**Subject: midtown Project
Applicant's Response to Planning Staff Comments**

The Federated Companies has received and reviewed the Planning Staff's January 13, 2015 comments regarding the Level III Site Plan & Subdivision Application Submission. The comments are listed (*italicized*) followed by our responses. Our responses have been grouped by each planning staff member. We are only responding to comments that require action from our office. Also appended to this letter as Attachment A are the non-technical responses prepared directly by the Federated Companies; Attachment B which includes the updated B-7 Design Guidelines and waiver request information prepared by CBT Architects.

SHEET TITLE  
GRADING & DRAINAGE PLAN  
midtownFour

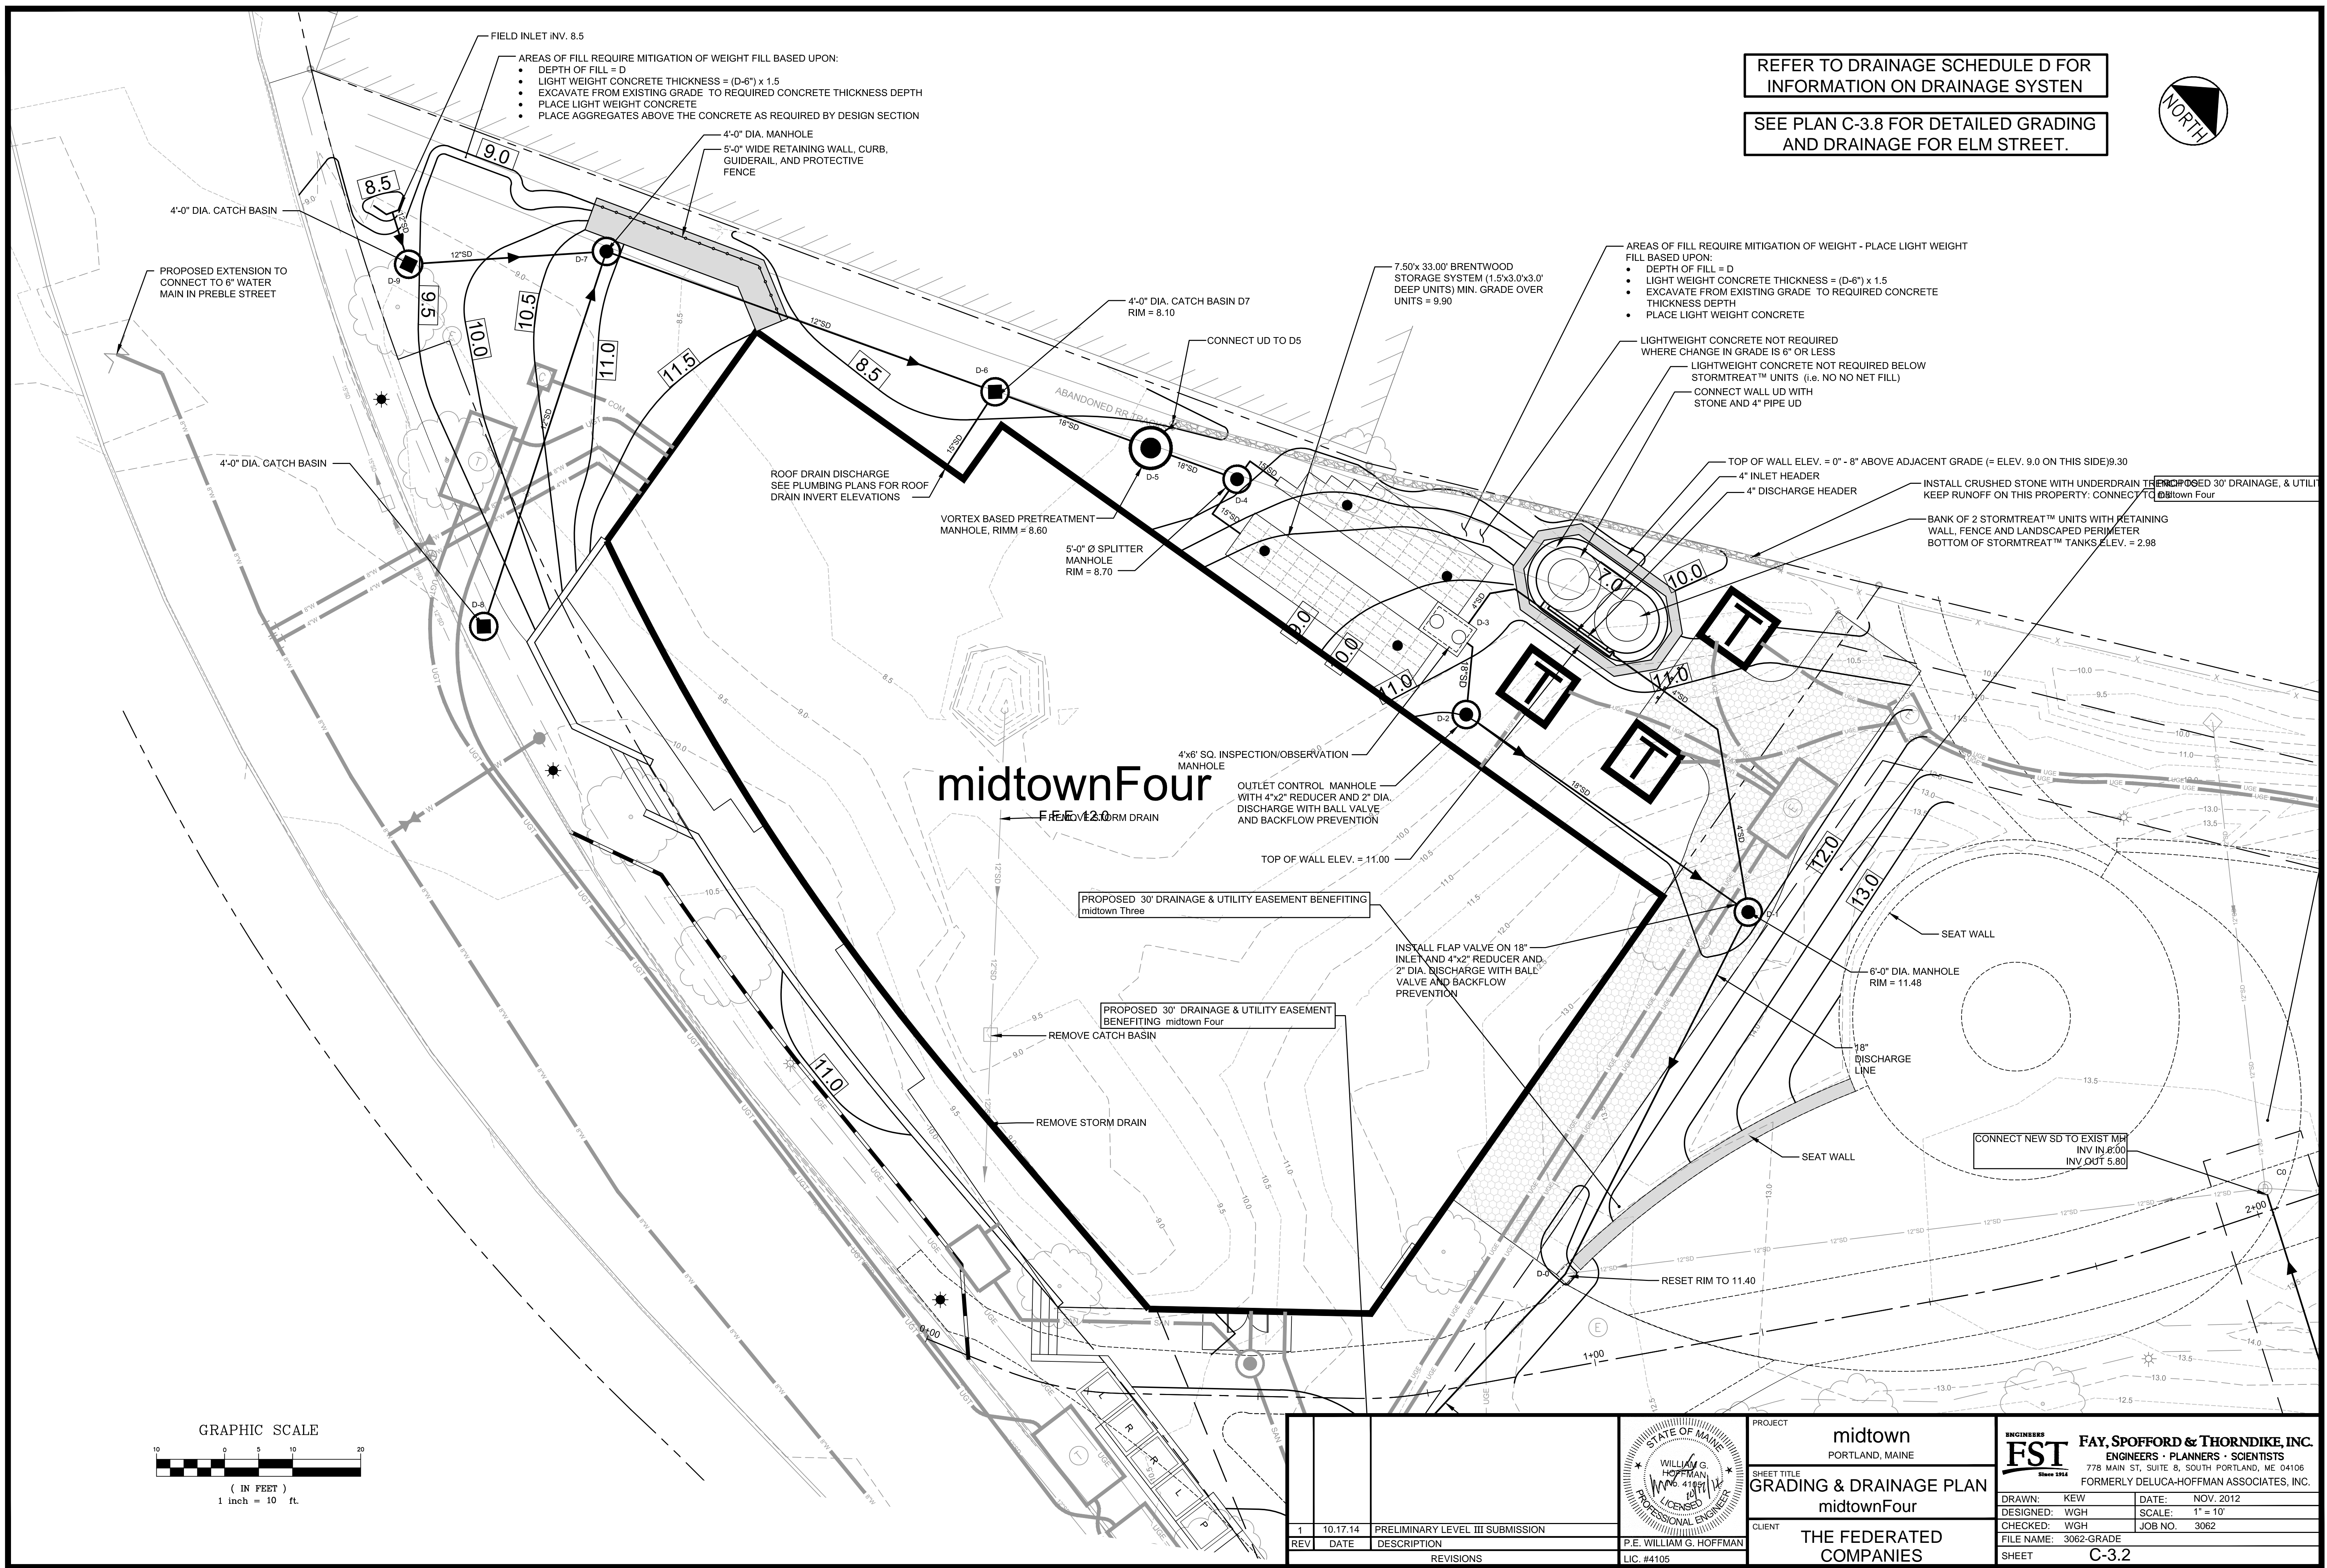
- c. *Please indicate for Elm Street that the 12" drainage line will be increased to 24". It is the City's intent to pay for this drain extension which will be bid with the applicant's work. Plans will need to be submitted for review.*

This has been indicated on the enclosed Sheet C-3.2.

**TYPICAL CROSS SECTION
ALONG "PINCH POINT" BEHIND midtown Two (High)**
SCALE: 1" = 4' Horiz., 1" = 8' Vert.

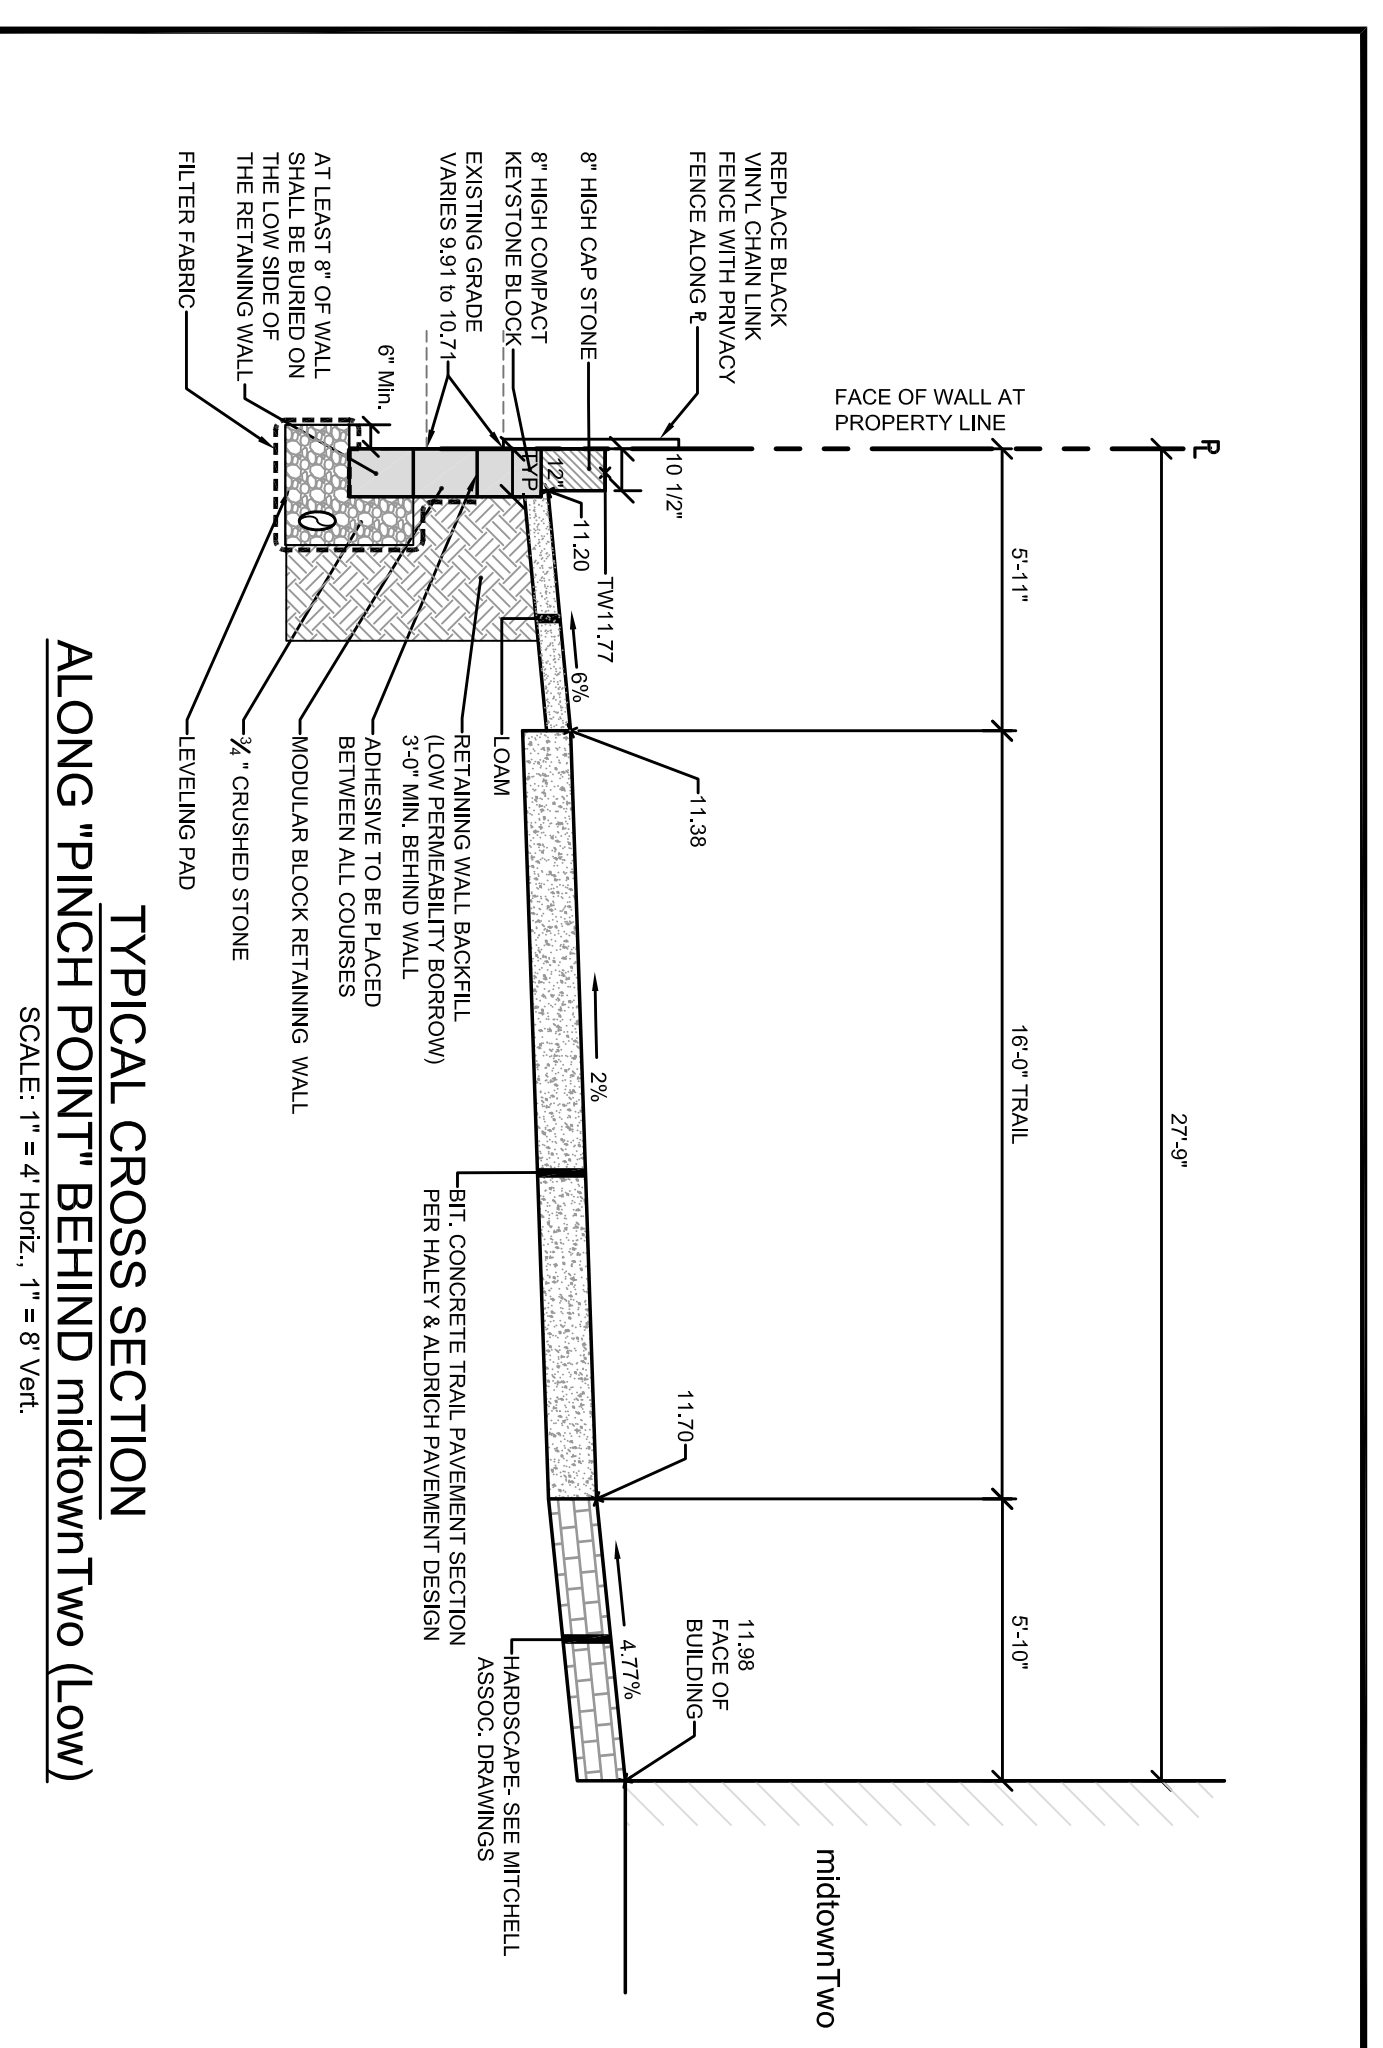
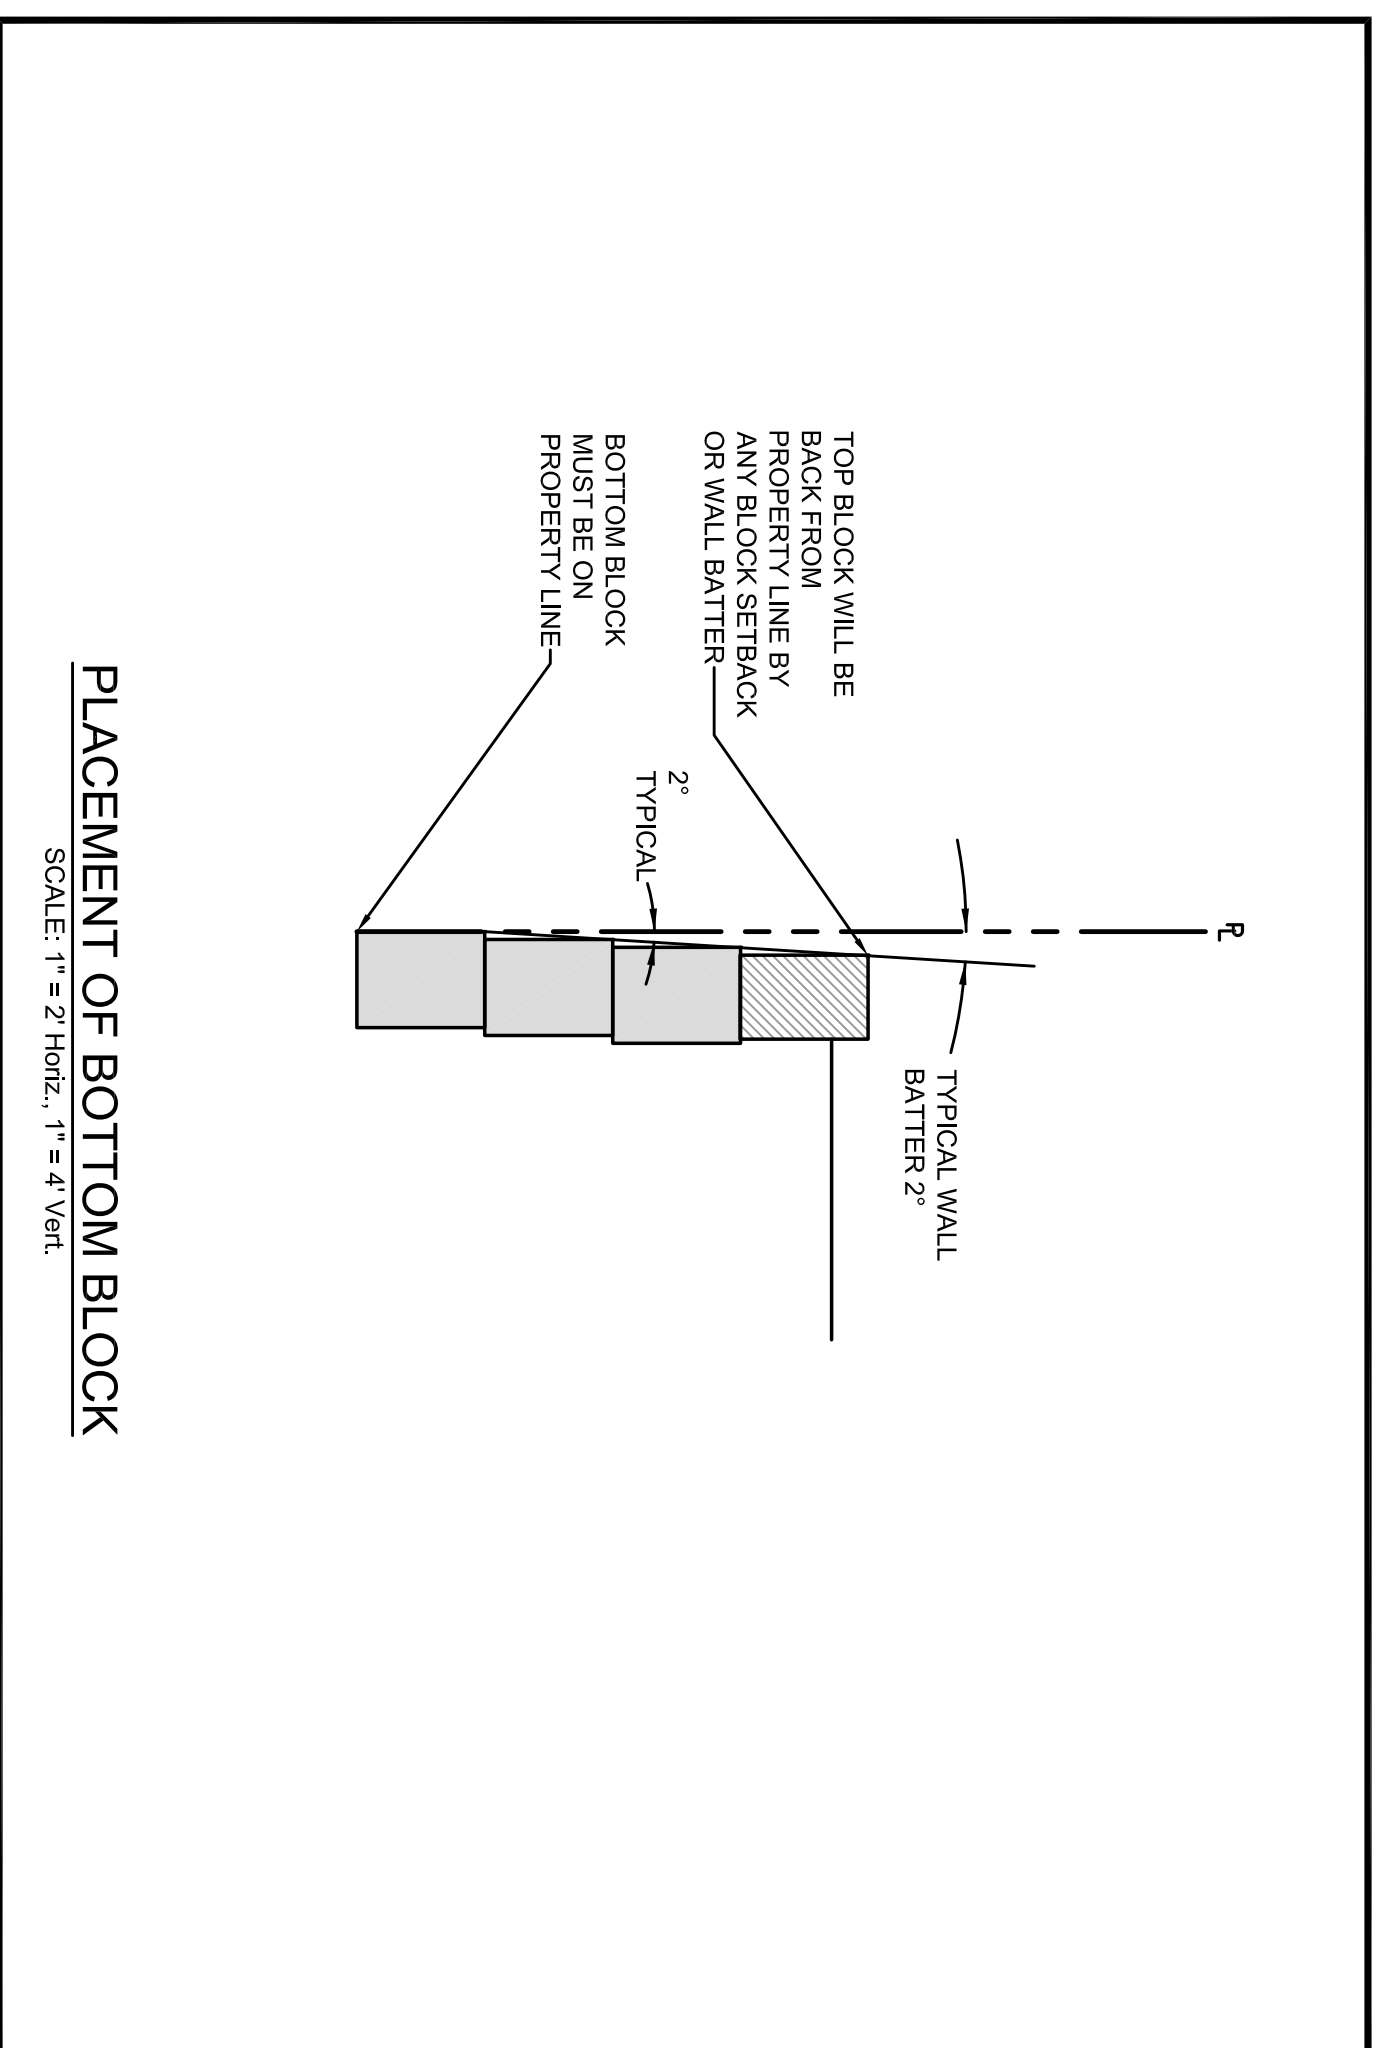
9. *The following comments are specific to the proposed grading and drainage concept for the areas behind midtown One and midtown Two, from Bayside Trail STA 6+50 to STA 12+50; refer to sheets C-3.0 and C-7.12:*

- b. *The face of the retaining wall and fence are proposed primarily on the property line between City of Portland (Bayside Trail) property and the parcels located north of the Bayside Trail. Temporary construction agreements will be required from the adjacent property owner to complete the work as proposed, as construction activity will be required on adjacent property to install the retaining wall and drainage systems.*

We understand these requirements and currently believe that temporary access rights will be available from the abutting landowner. Evidence of these agreements can be provided prior to the issuance of a building permit.
